Statement of Response to An Bord Pleanála Pre-Application Consultation Opinion

Proposed Strategic Housing Development
Clongriffin SHD 2
Lands at Clongriffin, Dublin 13

Gerard Gannon Properties

TITLE **PARKING SPACES LAYOUT**

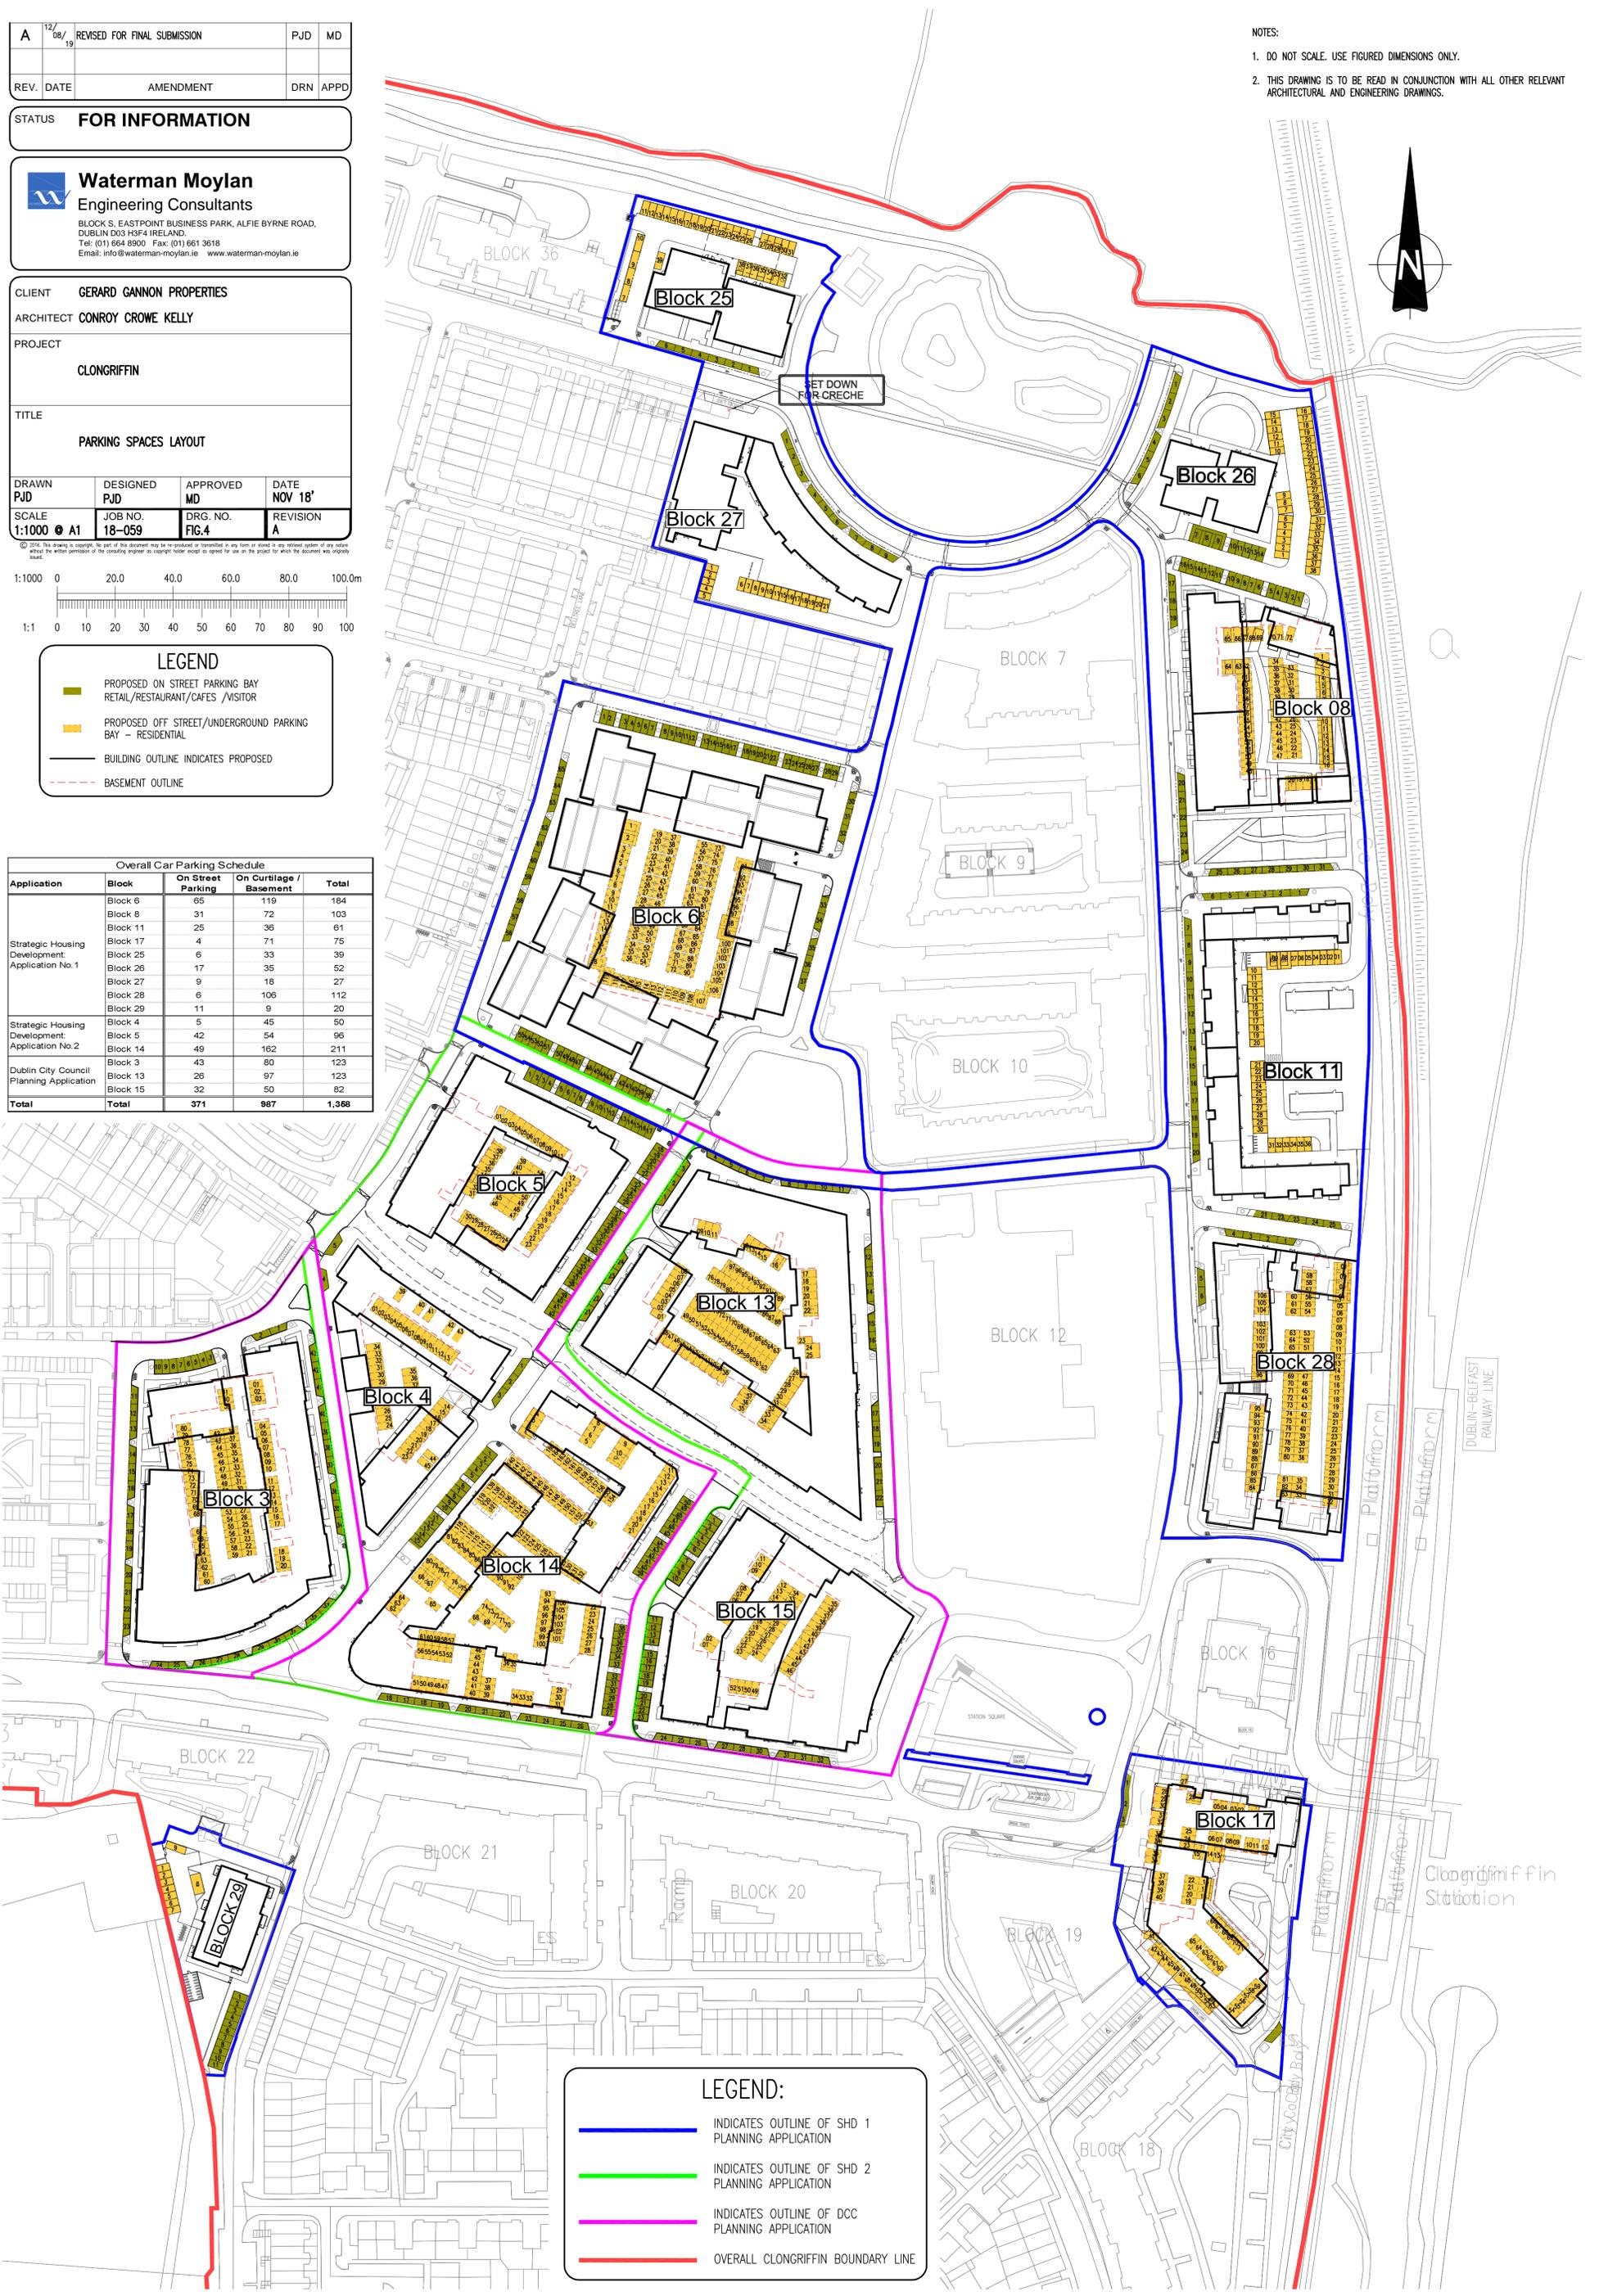
A detailed car parking strategy and rationale which outlines in particular measures to direct care users within the scheme to available parking spaces.

A detailed car parking strategy and rationale document has been prepared by Waterman Moylan Consulting Engineers titled 'Proposals for Parking' and is enclosed with this application. The parking proposals address the existing and proposed parking at Clongriffin including the quantum, the location, the operation and management of parking for private cars, public transport, taxi, bus and cycle.

A total of 2,555 spaces will be provided at Clongriffin being 1,466 reserved spaces for residents, 623 shared spaces for visitors, staff, customers and 420 spaces for Park & Ride. The remaining 46 are pre-assigned for residents. The requirement and allocation of car parking for Clongriffin SHD 1 application, Clongriffin SHD 2 application and Clongriffin DCC Planning Application are fully set out within the enclosed report. Please refer to the enclosed 'Proposals for Parking' prepared by Waterman Moylan Consulting Engineers for further details.
